3, HIGHCROFT CLOSE
GLENWOOD ESTATE,
BOGNOR REGIS
W. SUSSEX,
PO22 8DS

REV. No. BR/80/17/PL

I am writing to you with reference to planning BR/80/17/PL, which is the land next to the pumping station in Slighcroft close.

PROPOSED GROUND FLOOR PLAN
& SITE BLOCK PLAN.

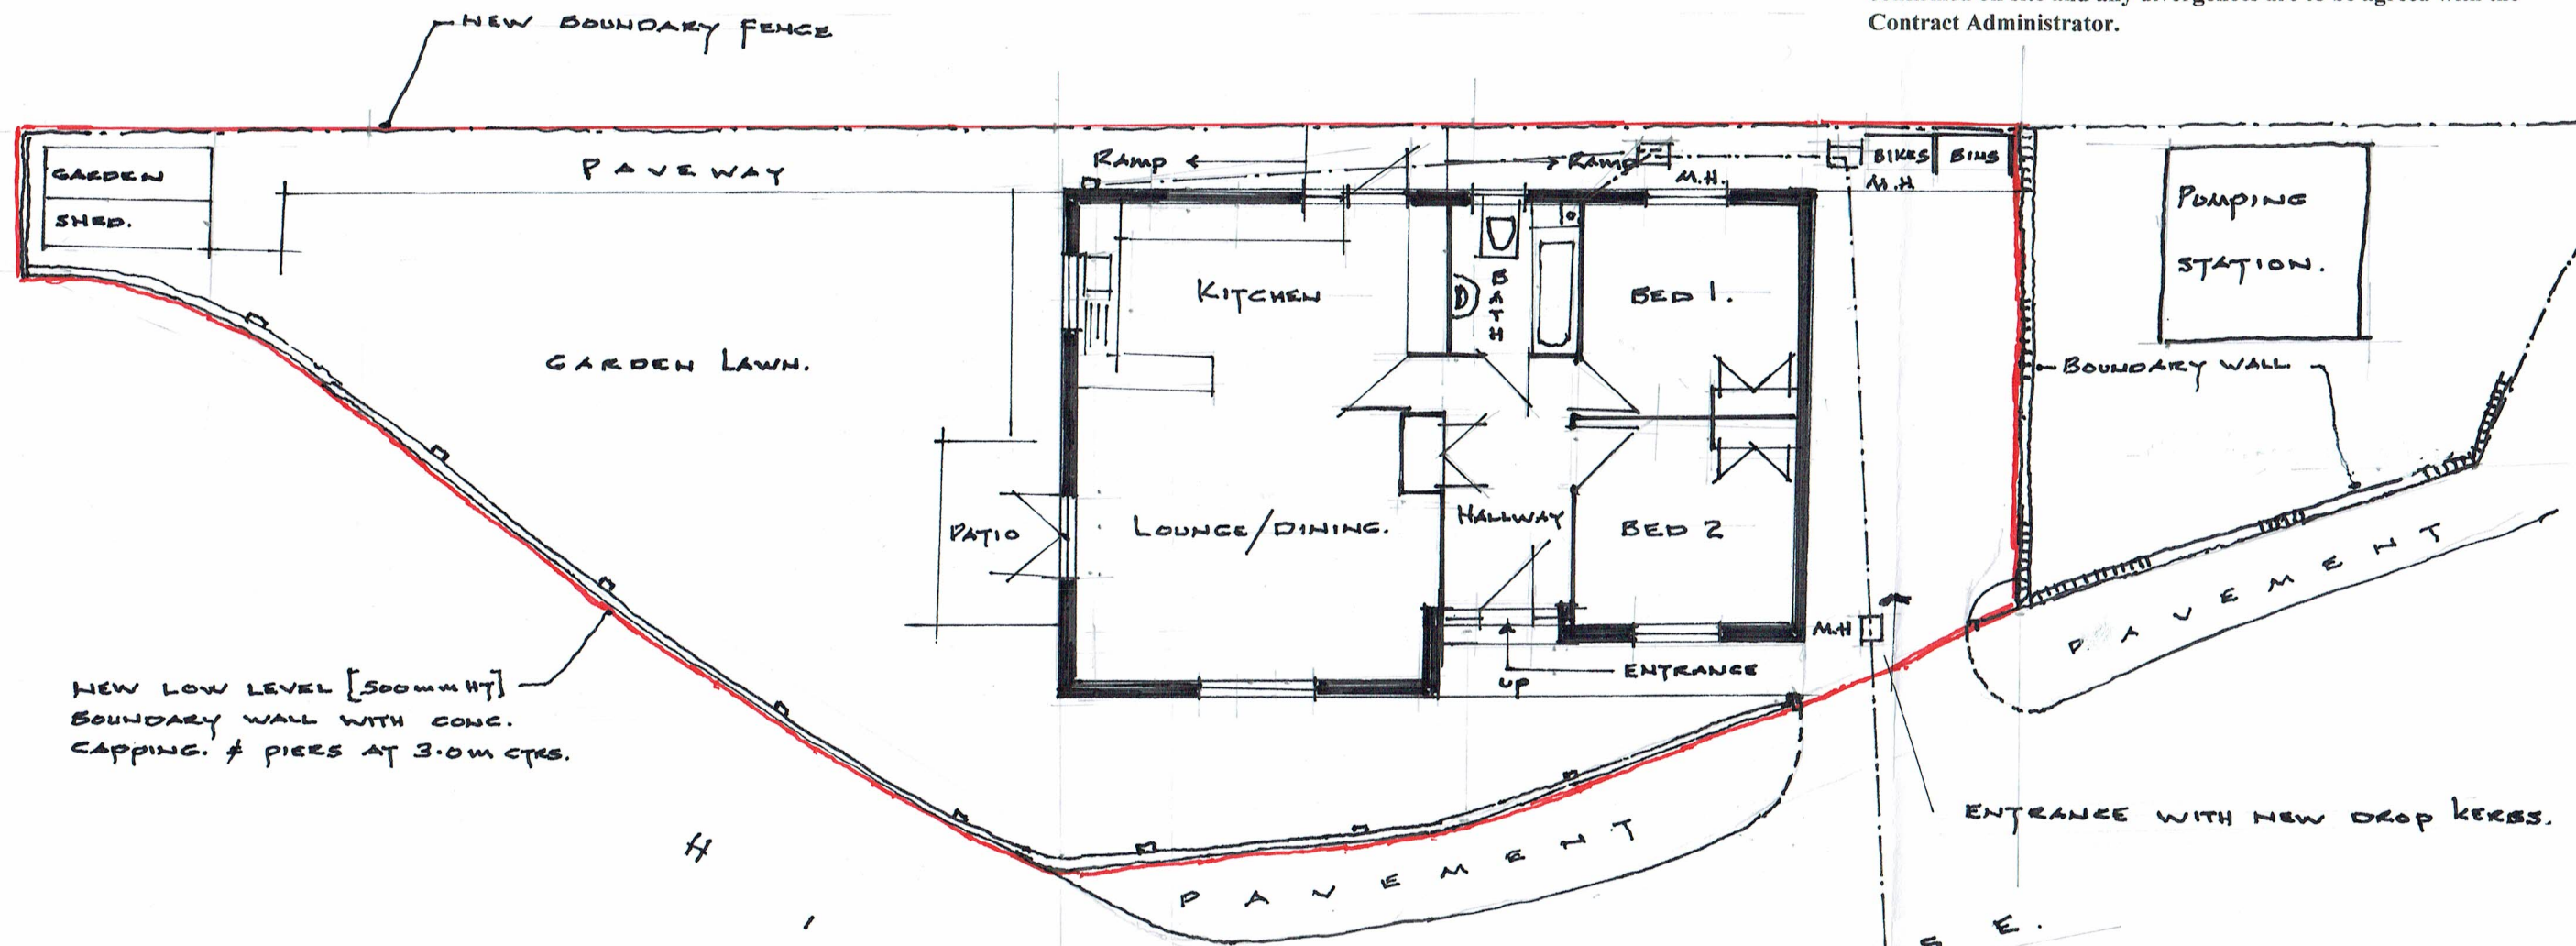
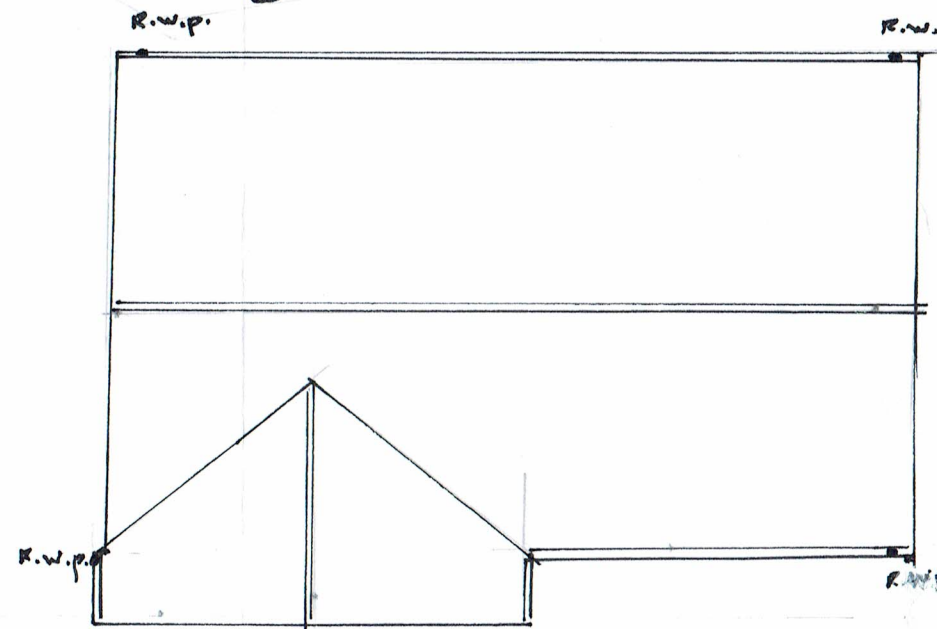
② All six bungalows in Higheroft Close have driveways which will take up to four cars, and I note that there is only parking for one car in the plans, and we are concerned that any on-road parking will make problems for us, and other road users i.e. refuse collection etc.

- ⑤ All the bungalows on this ^{estate} have lounge and kitchen at the rear - I note that this new bungalow has a lounge/diner at the front which will overlook all our bedrooms in the close, which I feel would be a loss of privacy for all six bungalows in the close.

Also the new boundary wall is so low that we will lose a lot of privacy when people:

The proposed plot is small with Kitchen and Lounge facing road overlooking our bedrooms. With its glass patio doors leading to small garden with a low wall again overlooking bedrooms that face onto this plot.
